Recommendation Report for Planning Permission for Works or Extension to a Dwelling

REF NO: FG/52/22/HH

LOCATION: 6 Beehive Lane
Ferring
BN12 5NL

PROPOSAL: Erection of two storey front extension with front canopy, single storey side and rear extension and extension of loft to habitable use including the installation of 1 x side dormer.

1 PROPOSED GROUND FLOOR
2002 Scale: 1 : 50

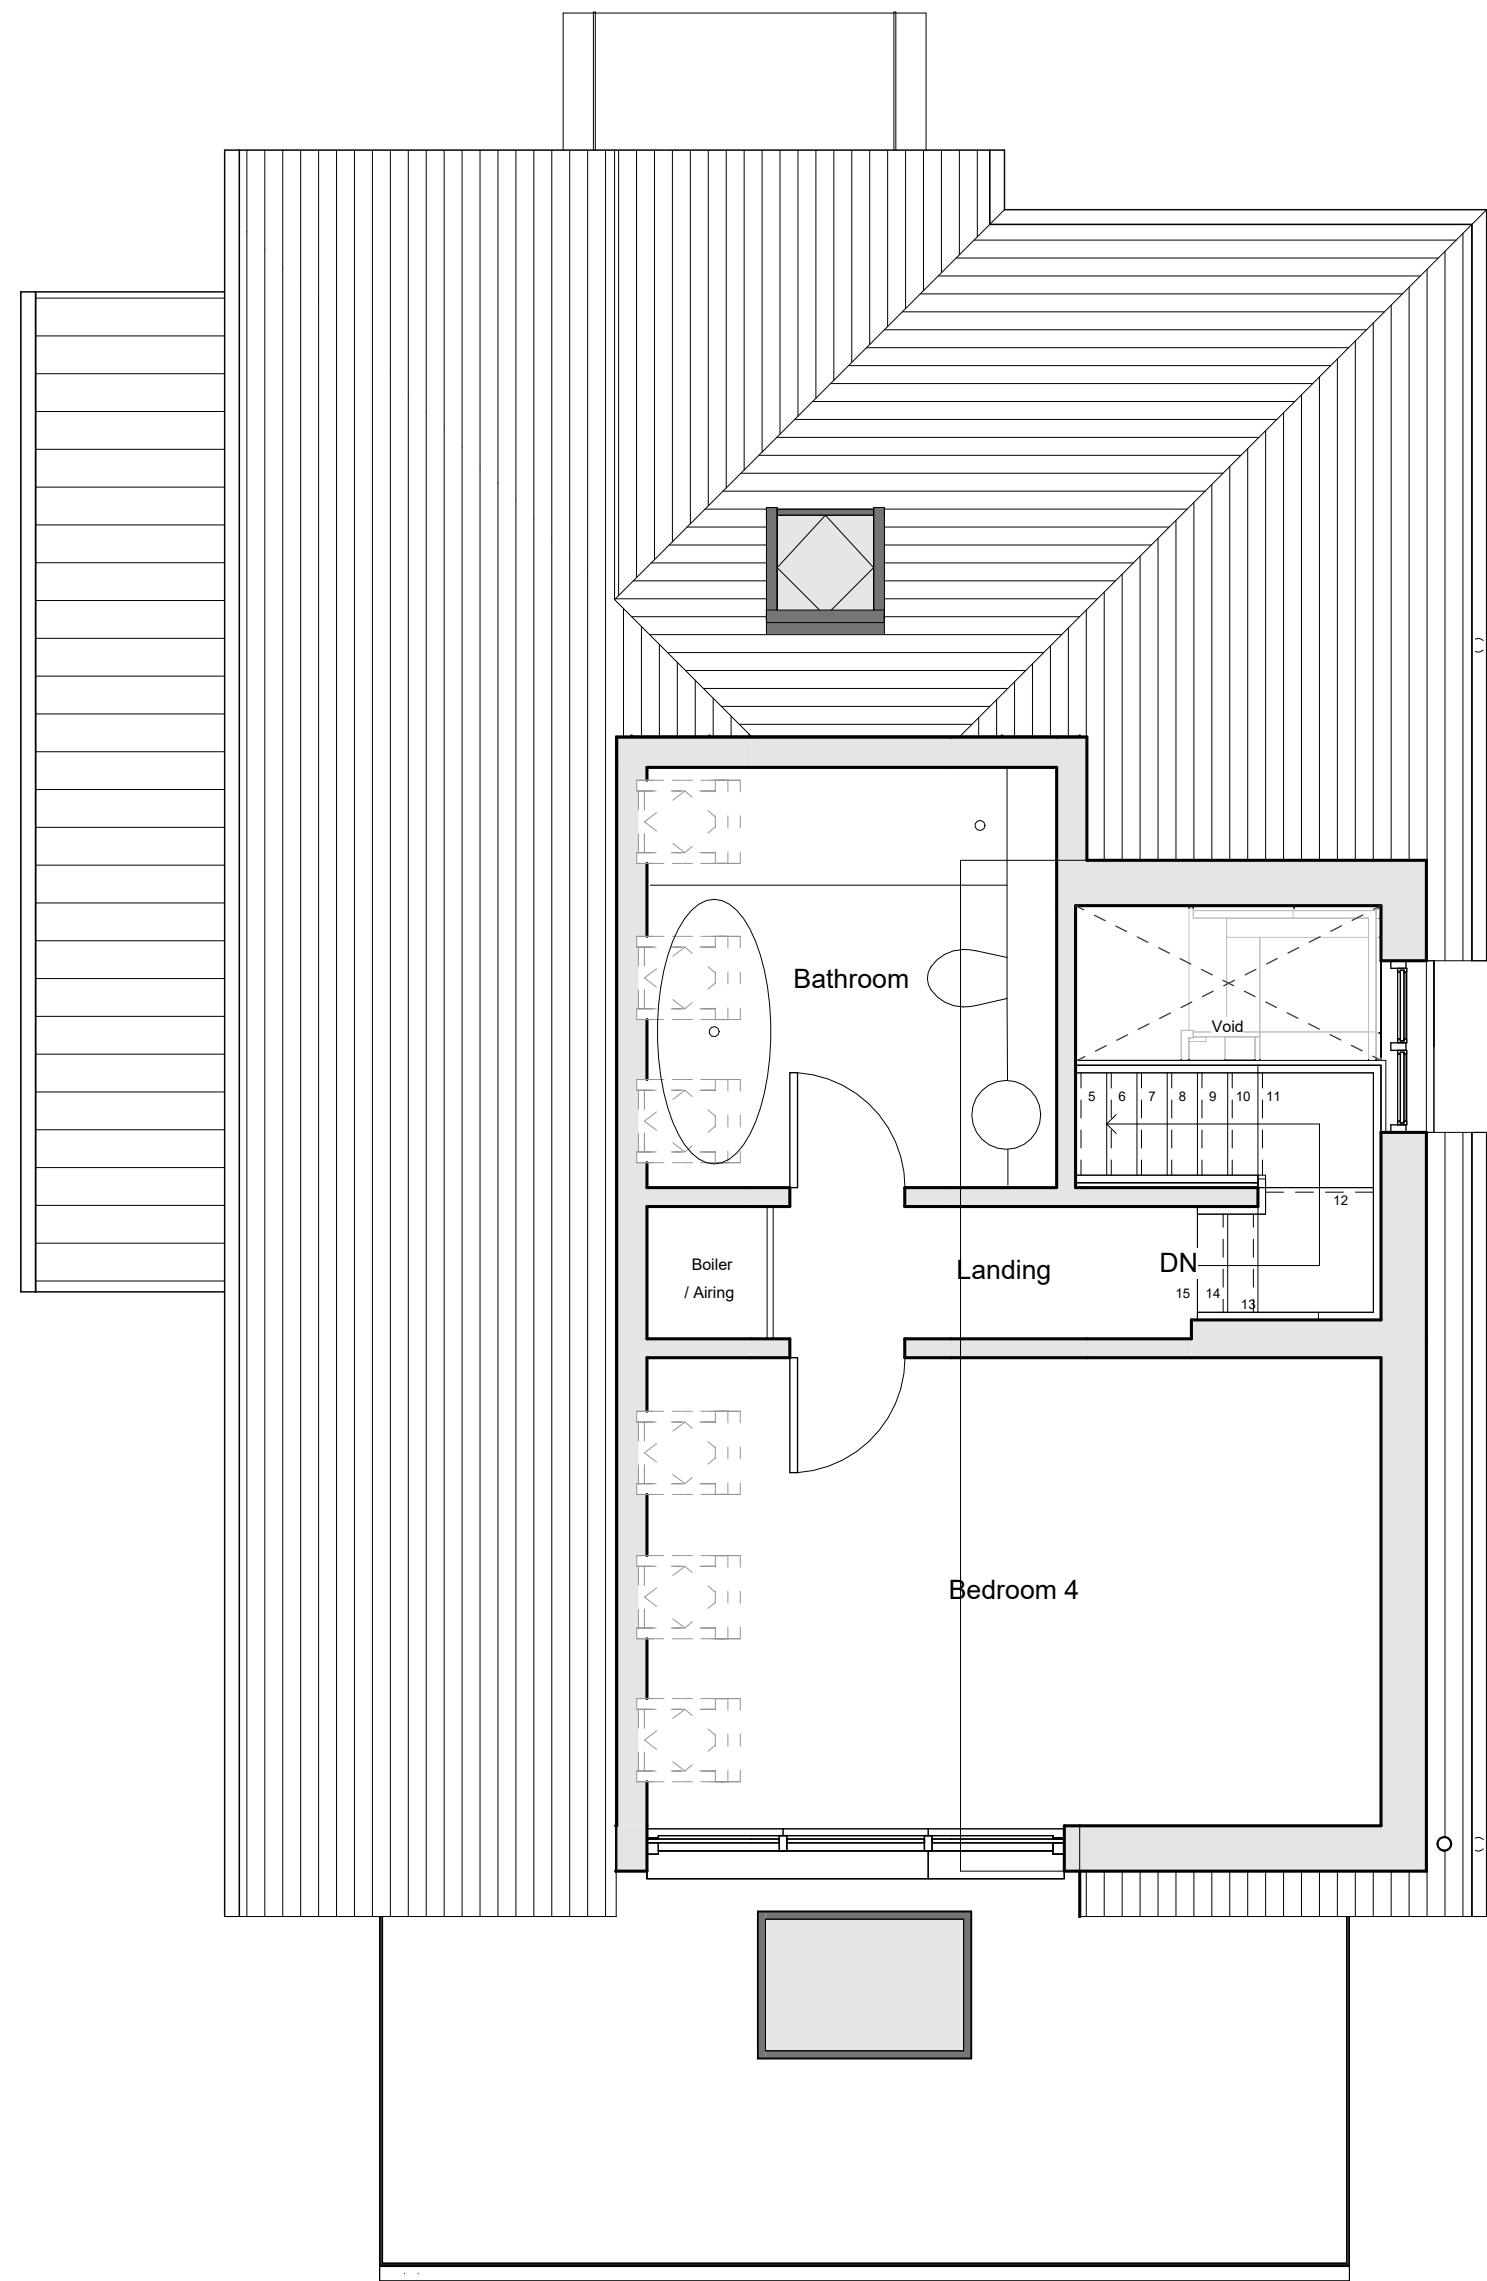
The proposed development will only encroach on the front (north) and side (western) boundaries, no development will extend past the existing line of the eastern or rear elevations. The single-storey side extension sits on the boundary with No 4A as the existing building does. To the west there is a 1.8m separation gap between the building and the shared boundary.

The single-storey side extension and two-storey front extension by reason of their location on site, orientation and scale are not considered to be overbearing or overshadow the neighbouring property to the west.

Comments have also been received regarding concerns for privacy through overlooking. No new views which are not already achievable will be created from any of the proposed fenestration located on the northern or western elevations. The roof lights to the western elevation appear to be above 1.7m from finished floor level, other windows face the public realm. The windows to the east are described within plans as obscure glazed, all other windows above ground floor levels are as existing. The glazed gable to the southern elevation has a direct back-to-back relationship with No 4 Chalet Close. The glazing at first floor level to the southern elevation will be lessening and will therefore improve the situation however, new glazing will be introduced at second floor level. This glazing replaces a much smaller rear gable which is set back by over 1.5m from the rear line of the elevation, by moving the glazing forward the 1.5m only 19m is retained between the two facing elevations, without control this would provide an unacceptable form of development. This window along with the other side windows/veluxes mentioned above will be conditioned to be non-opening and obscure glazed, to protect the privacy of all surrounding neighbours.

The first floor window to the western elevation serving Bedroom 2 shall be a non-opening and fully obscured window below 1.7m from finished floor level prior to the first use of the rooms. The window shall be retained as obscure glazed/non-openable in perpetuity.
